DEVELOPMENT HEARING OFFICER

[PR-2021-005597](#)

SD-2024-00136 – PRELIMINARY/FINAL PLAT

MODULUS ARCHITECTS AND LAND USE PLANNING agent for RED SHAMROCK 12 LLC requests the aforementioned action(s) for all or a portion of: X2A, UNIVERSITY OF ALBUQUERQUE URBAN CENTER zoned NR-C, located at 3801 COORS BLVD NW between COORS BLVD and ST JOSEPHS containing approximately 26.5 acre(s). (G-11)

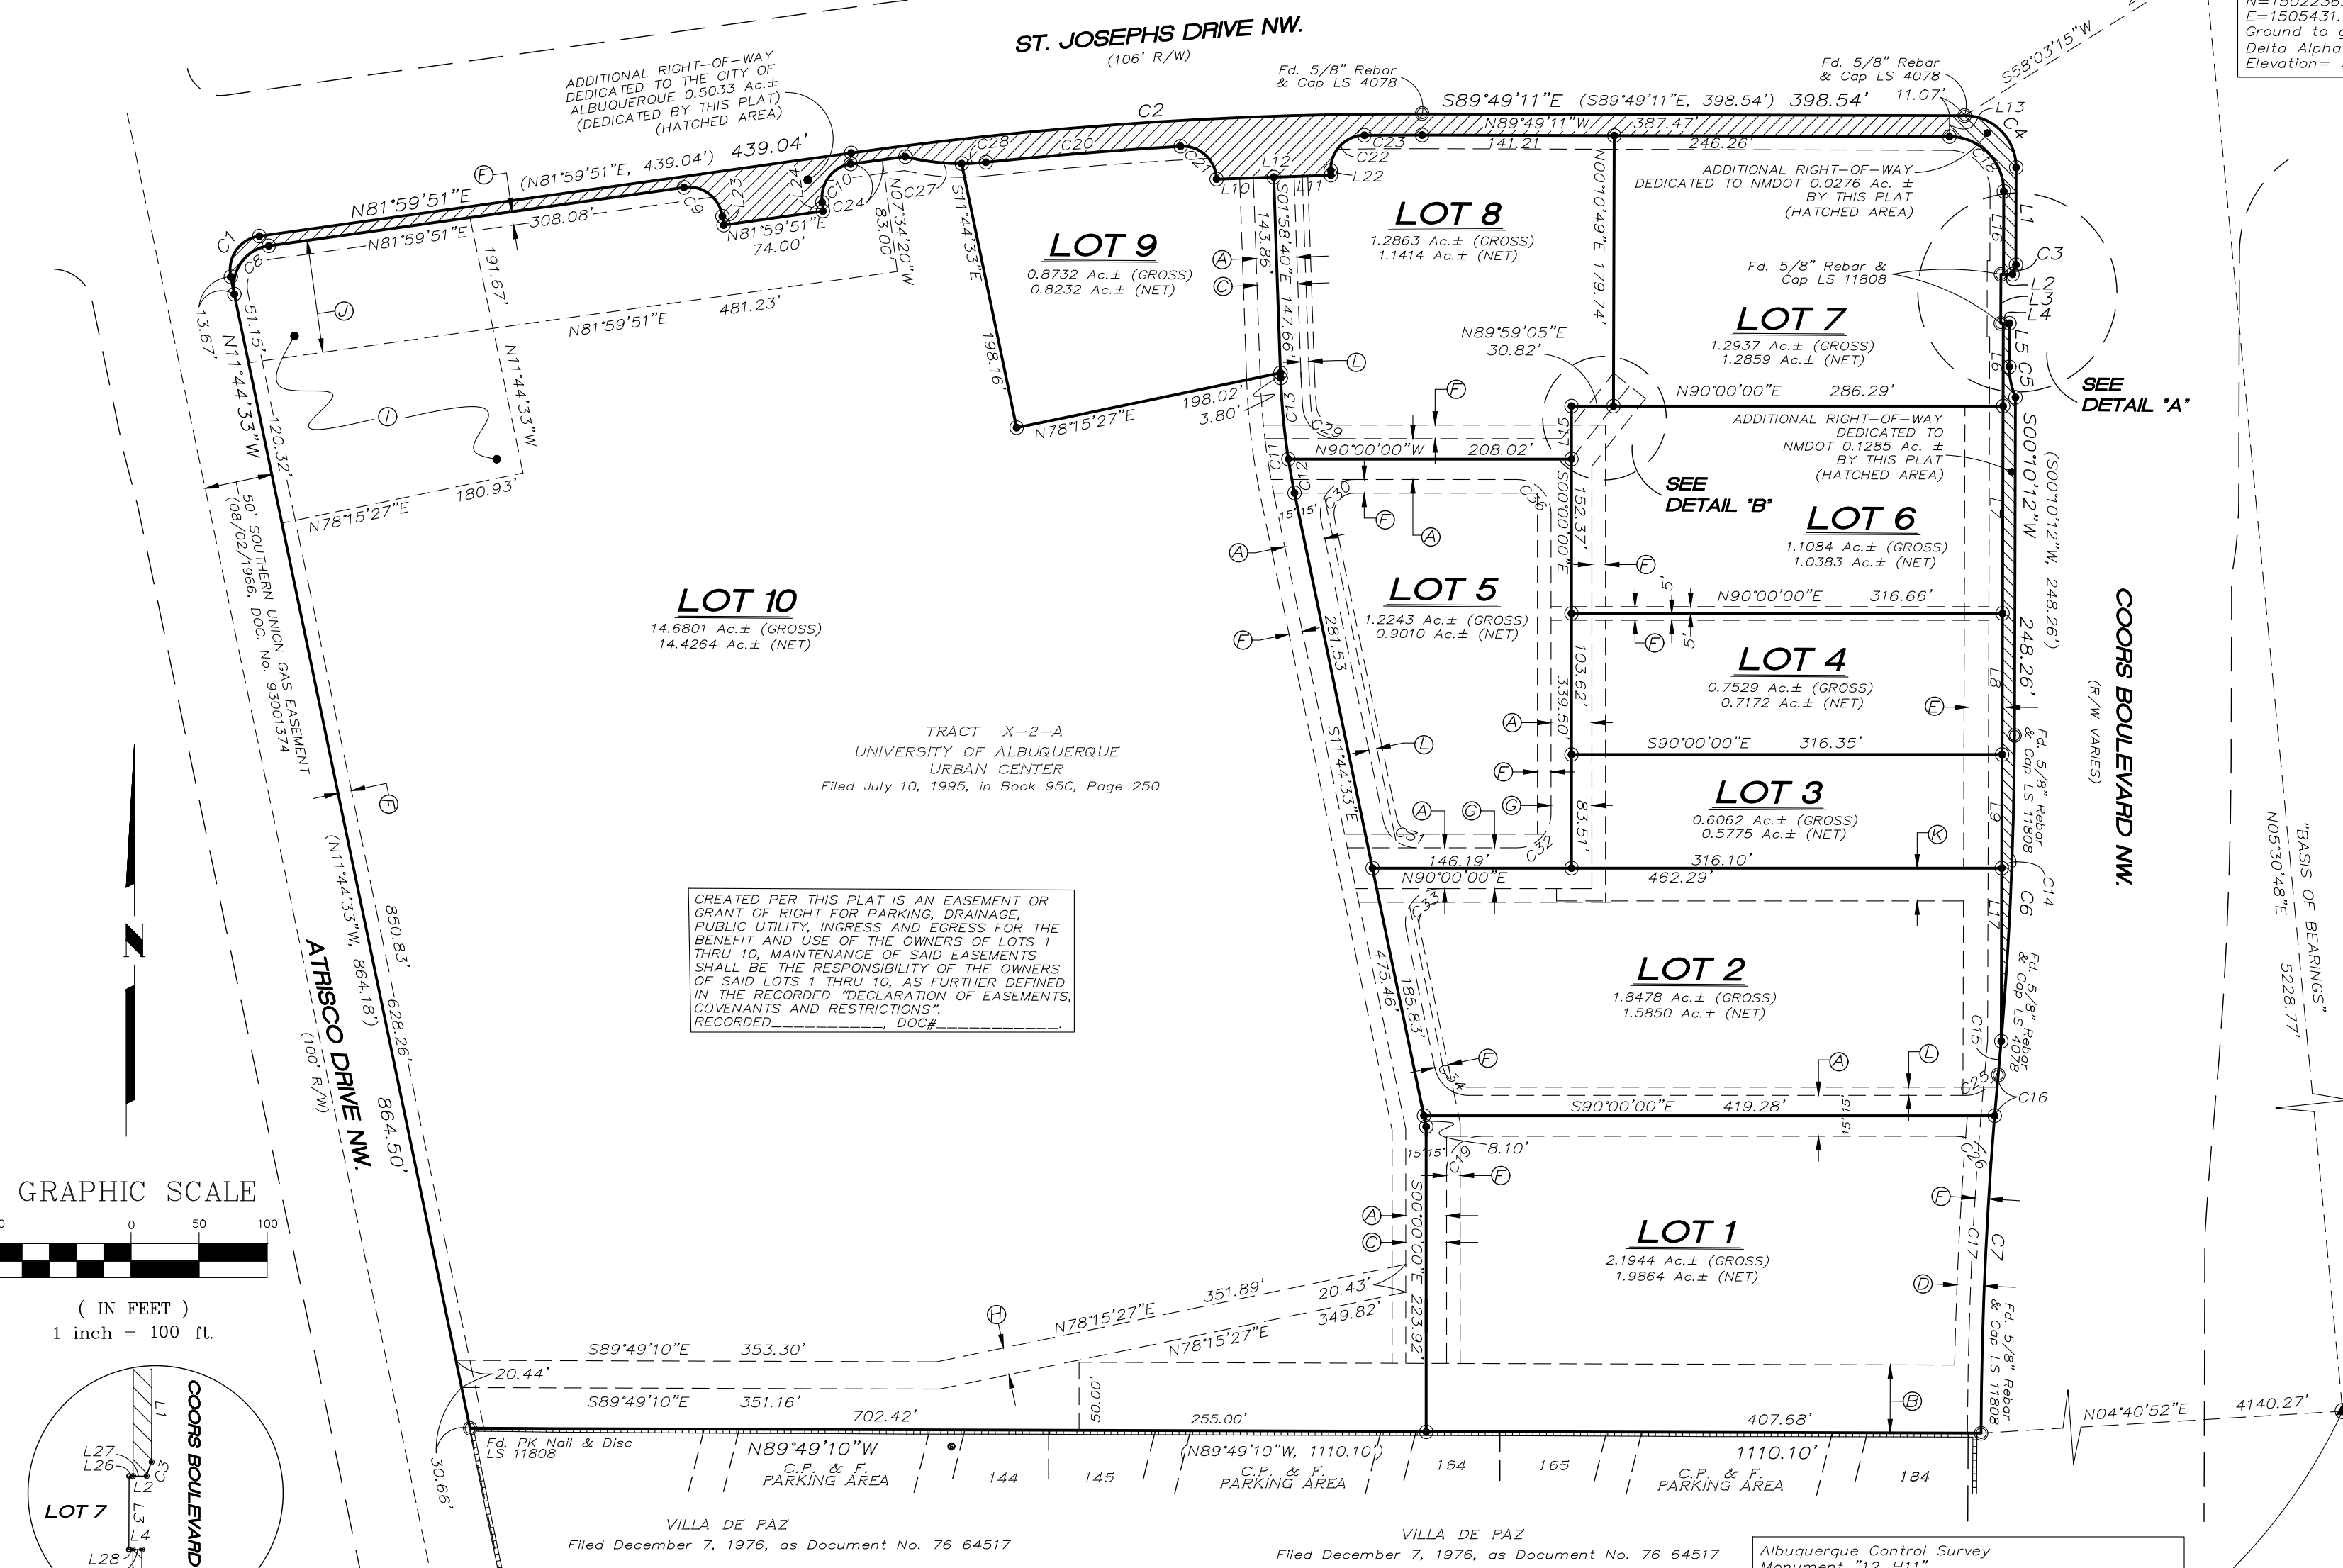
REQUEST: Corrections To The Plat For Easements “A” AND “L.” The Original Plat Approved Easement Notes “A” AND “L” which were mislabeled As “Public” Instead Of “Private Easements.” The Easements In Question Are Internal To The Site

- After the noted Final Plat was approved by the DHO on May 10th, 2023 and recorded, the Applicant noticed that corrections to the Plat for Easements A and L were necessary, as they were incorrectly labeled as public easements when they should have been labeled as private easements. As a result, the Applicant has submitted a Preliminary/Final Plat with the corrected easement notes.

- A “clean” version of the Plat featuring the corrected easement labels for Easements A and L as well as the project and application numbers for this Plat must be submitted prior to final sign-off of the Plat should this Plat be approved by the DHO.
